WEST SUSSEX COUNTY COUNCIL CONSULTATION

TO:	Arun District Council FAO: Simon Davis
FROM:	WSCC - Highways Authority
DATE:	20 July 2021
LOCATION:	Brookview Nursery Eastergate Lane Arundel BN18 0BA
SUBJECT:	WA/58/21/PL The removal of outdoor storage, including caravan & polytunnels, the erection of 7 workshop units comprising of 12 offices & 3 commercial units, associated parking, drainage and turning spaces. This application is in CIL Zone 3 (Zero Rated) as other development.
DATE OF SITE VISIT:	n/a
RECOMMENDATION:	No Objection
S106 CONTRIBUTION TOTAL:	n/a

Drawing No.	2020-6286-001	Rev.	B
-------------	---------------	------	---

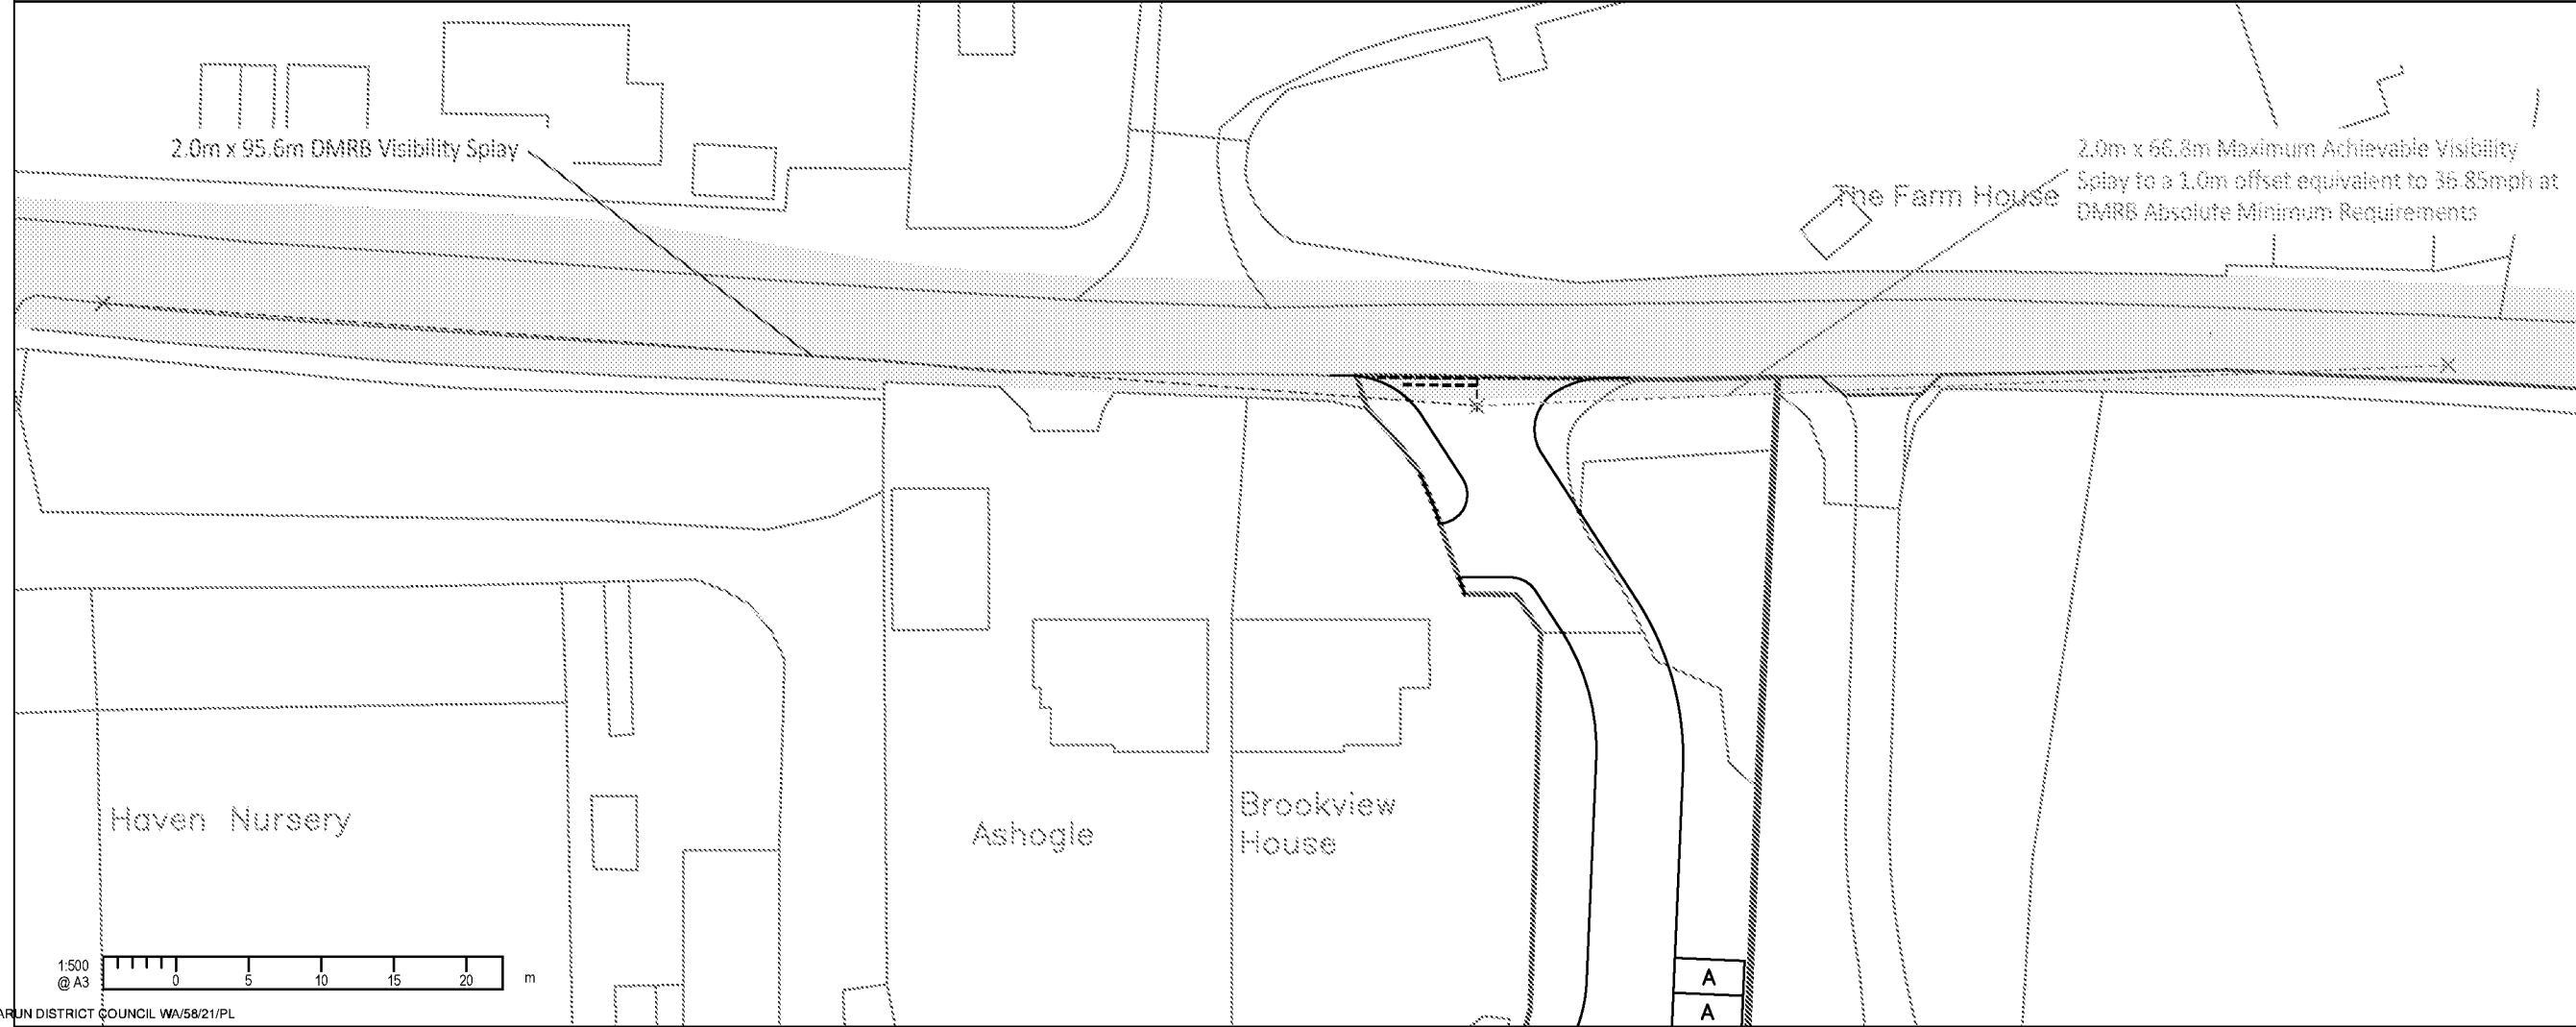
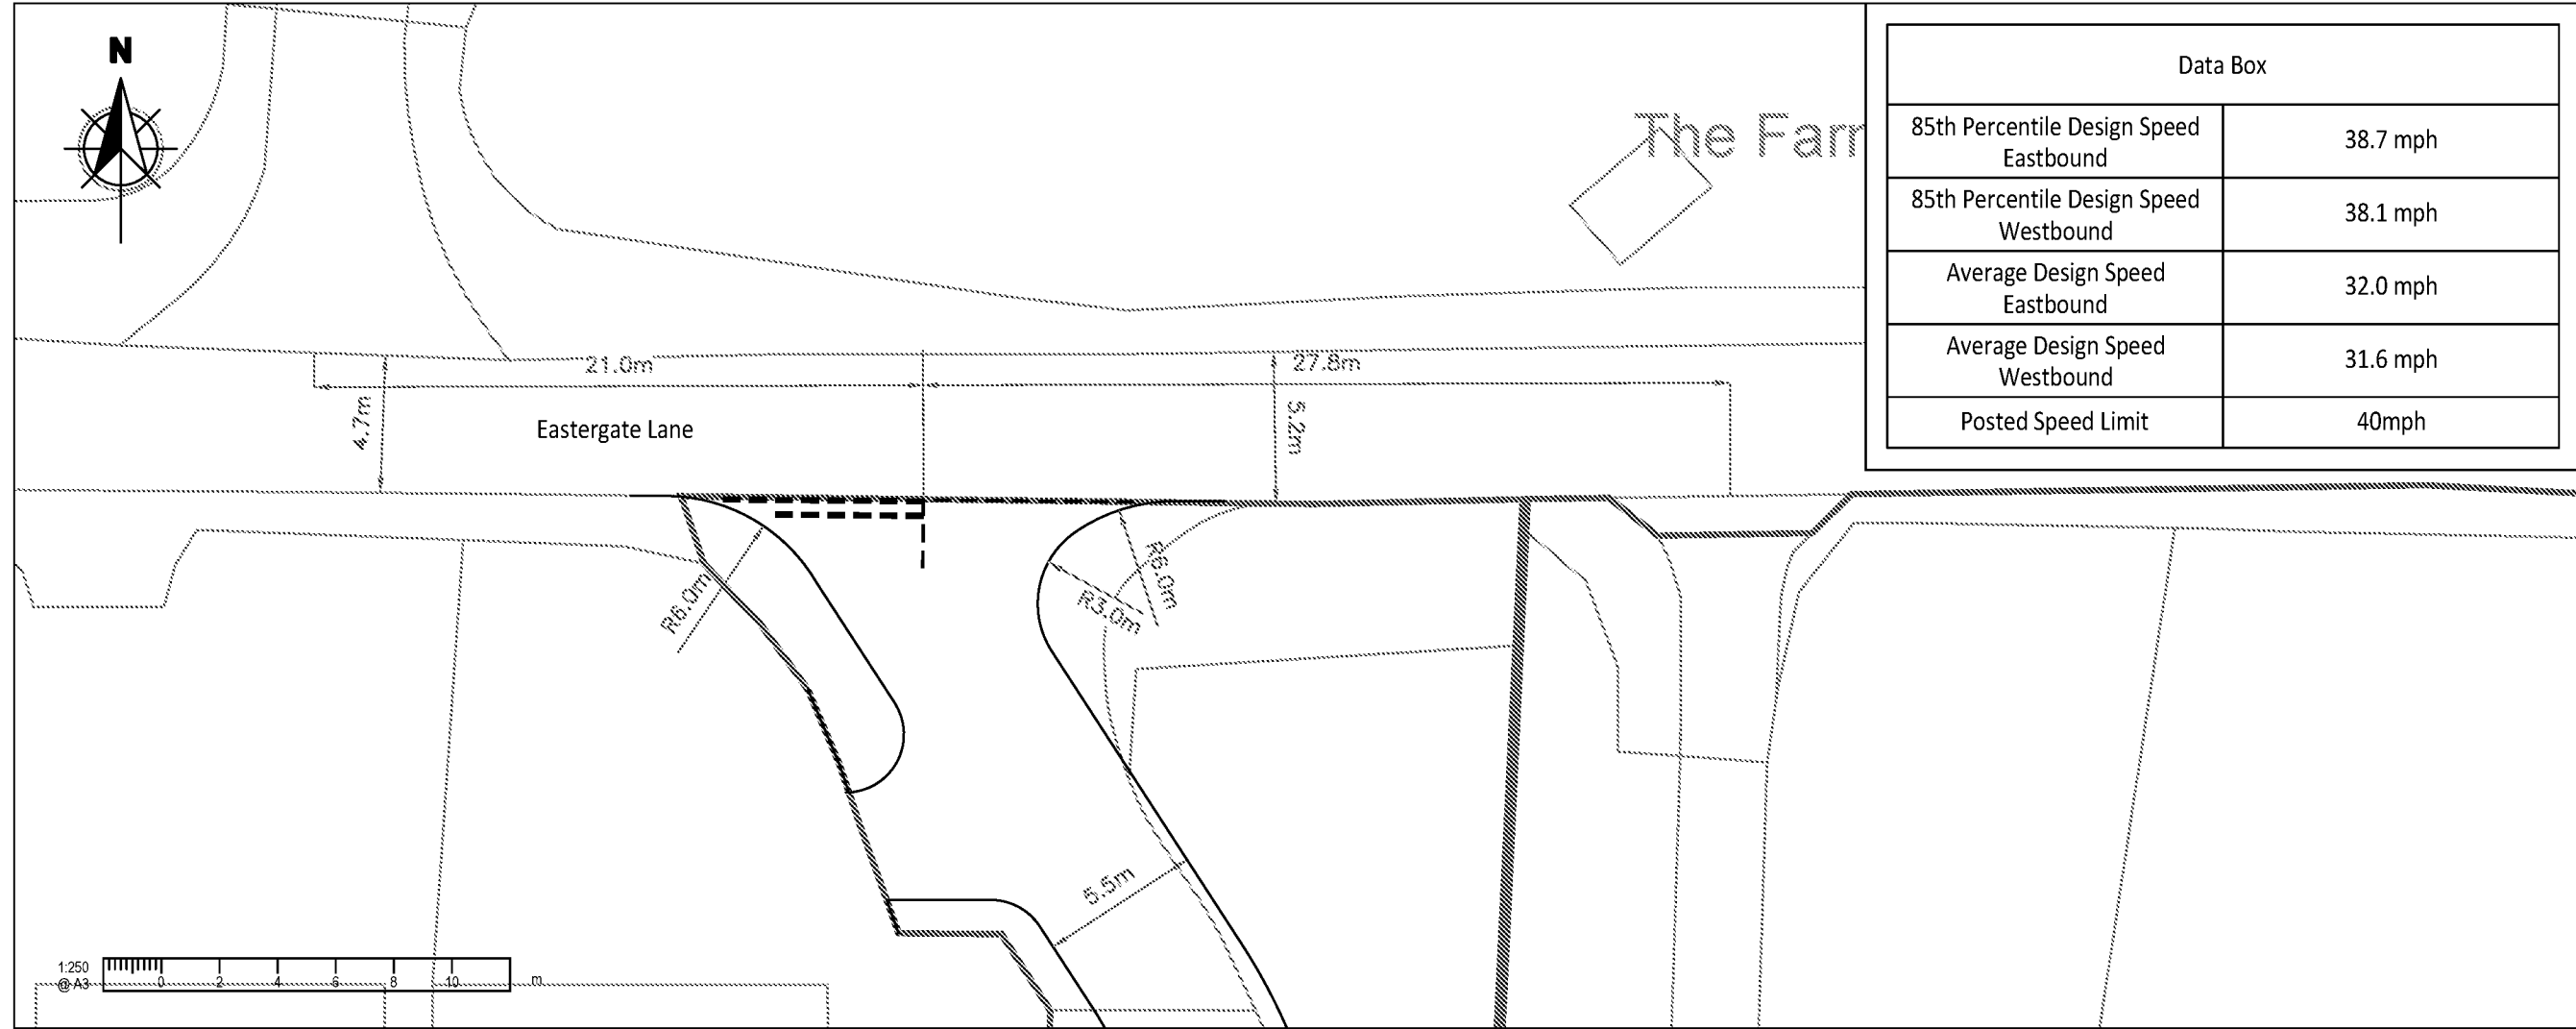
The access will be re-configured and upgraded as part of these proposals to 5.5 metres with 6 metre kerb radii. The works for access would be subject to a Section 278 Agreement with the LHA's Highways Agreement Team. The TS includes a speed survey which includes average and 85th percentile road speeds along Eastergate Lane. For ease of reference the recorded speeds were:

Both 85th percentile speeds were slightly below the posted limit of 40 mph. Visibility in line with Design Manual for Roads (DMRB and Bridges requirements can be achieved to the west at 95 metres. To the west 66 metres are achievable which is below the requirements of DMRB but within Manual for Streets 2 guidelines. The LHA would accept the splays on the basis that the proposals in essence are the existing access (albeit upgraded), the proposals are likely to see a less intensive usage over the existing use

On the basis of the above the LHA would be satisfied with the access strategy at the site.

No part of the development shall be first occupied until such time as the vehicular access serving the development has been constructed in accordance with the details shown on the drawing titled 'Access Overview and Visibility Splays' and numbered 2020-6286-001 Rev B .
